FAO: Planning Department,  
Welwyn Hatfield Borough Council

Ref: 6/2018/0136/LB  
Date: 22/10/2019

## HISTORIC BUILDINGS AND CONSERVATION ADVICE

**RE: *Oshwal Centre, Coopers Lane, Northaw, Potters Bar, EN6 4DG***

WINDOWS 10-11A

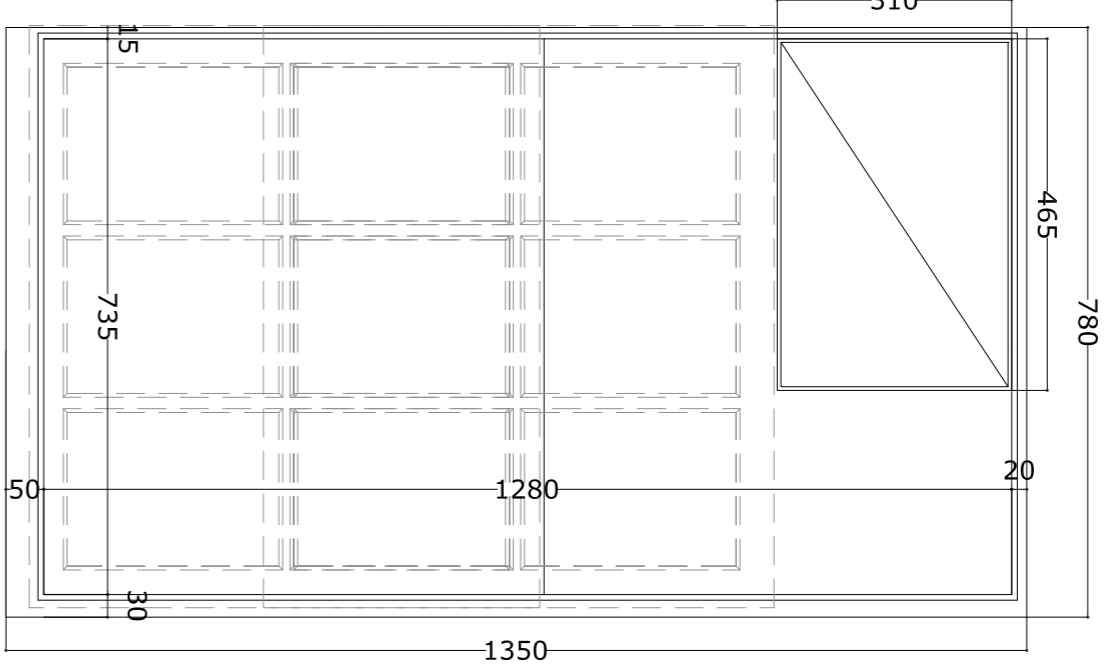
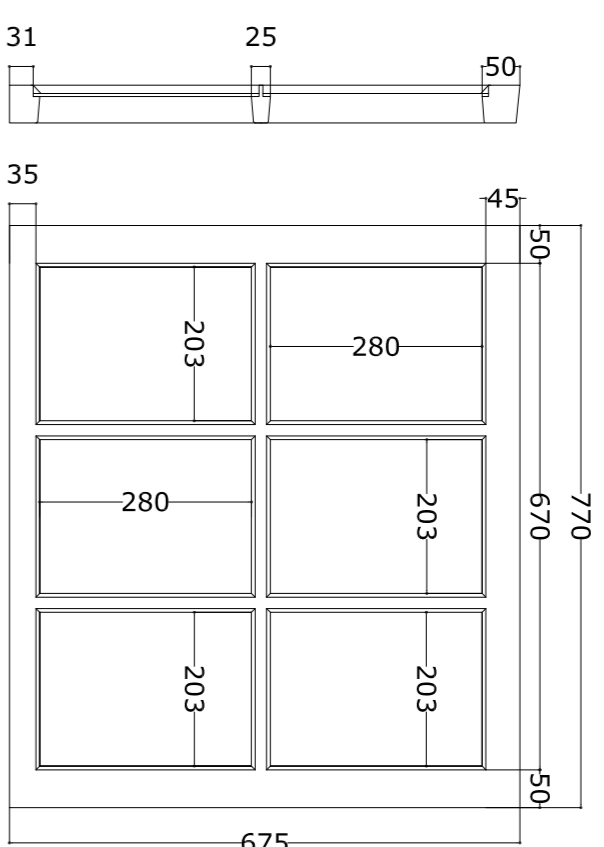
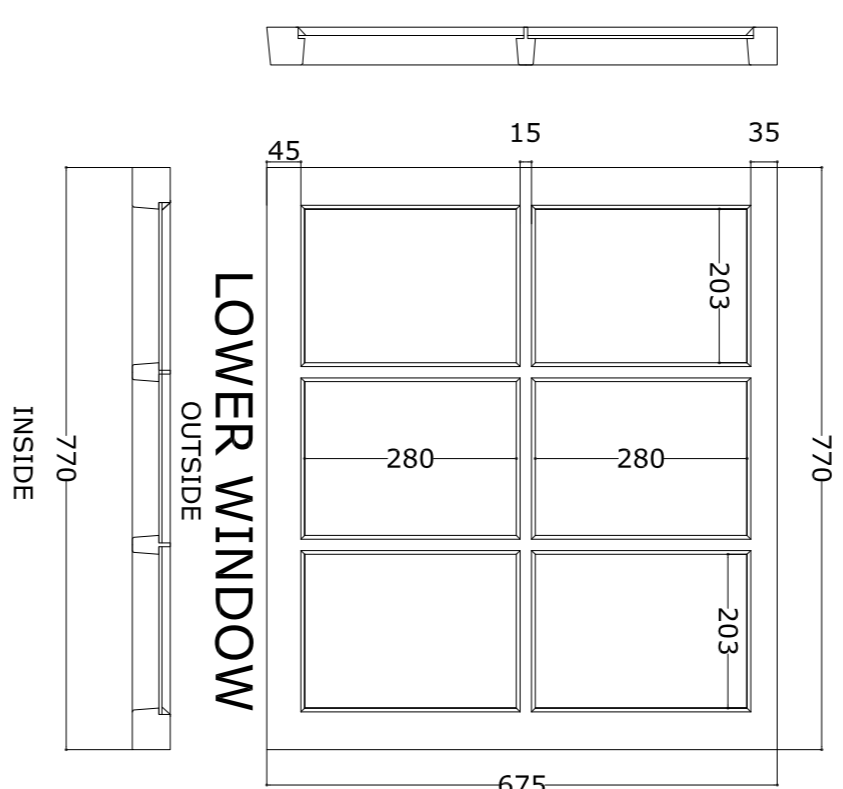
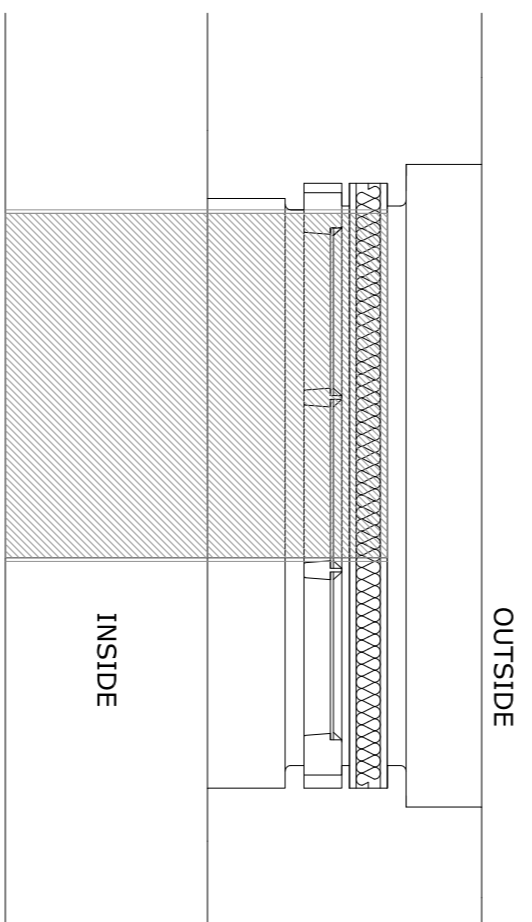
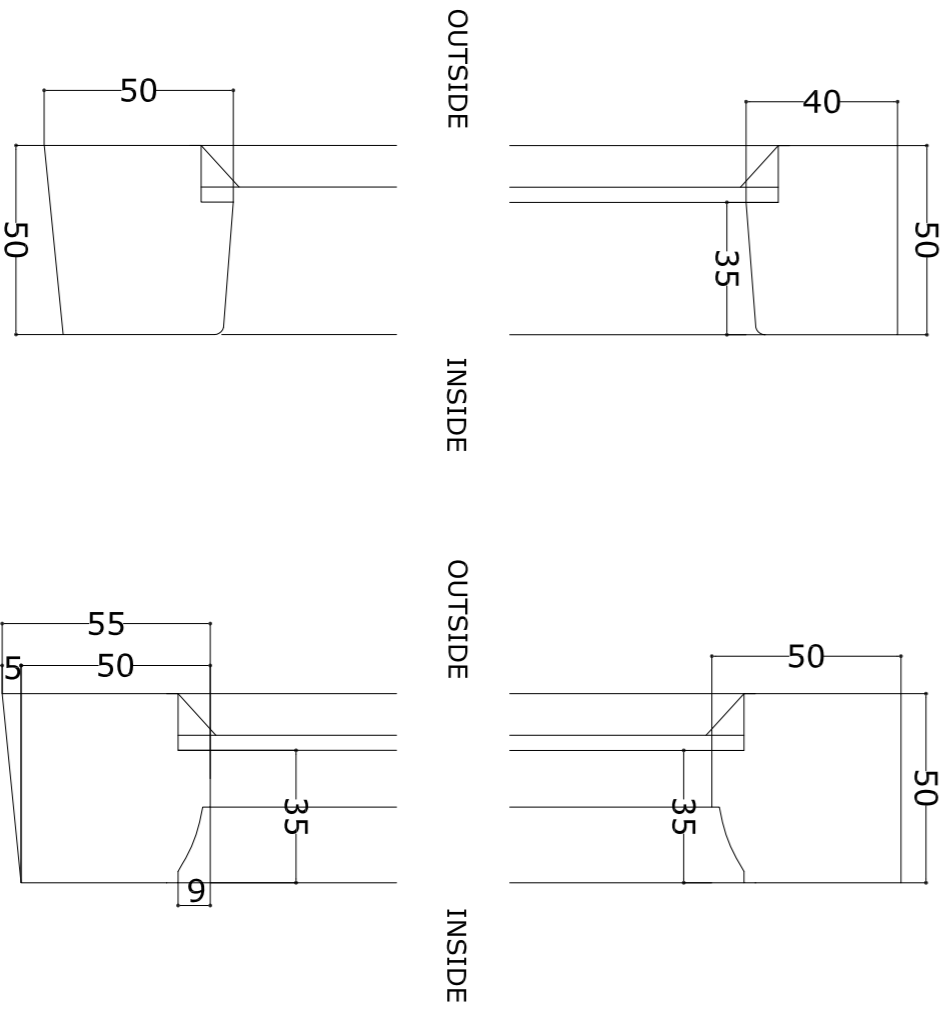
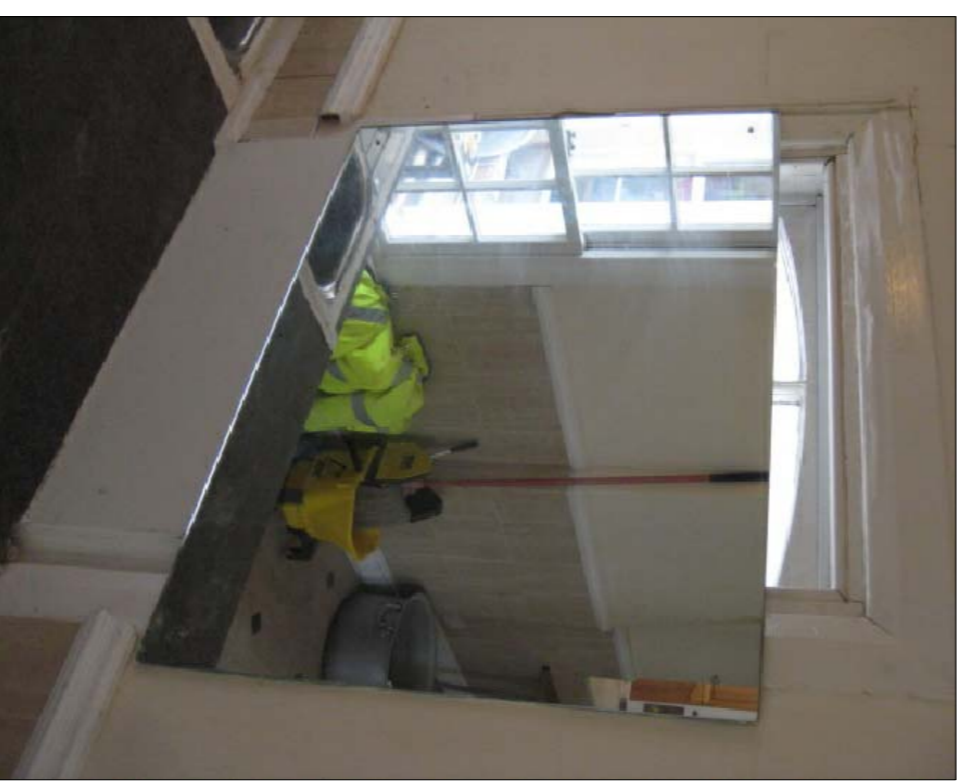
The replacement of the mid-late twentieth century windows (nos. .10, 11b, 11c, 33, 33b, 53, 54, 55 as per paragraph no. 2.14) raises no objection in principle but their replacements should be of a design more appropriate to the historic building, taking reference from the existing historic windows. Elevation and section details of the proposed windows is required to judge their impact on the listed building.
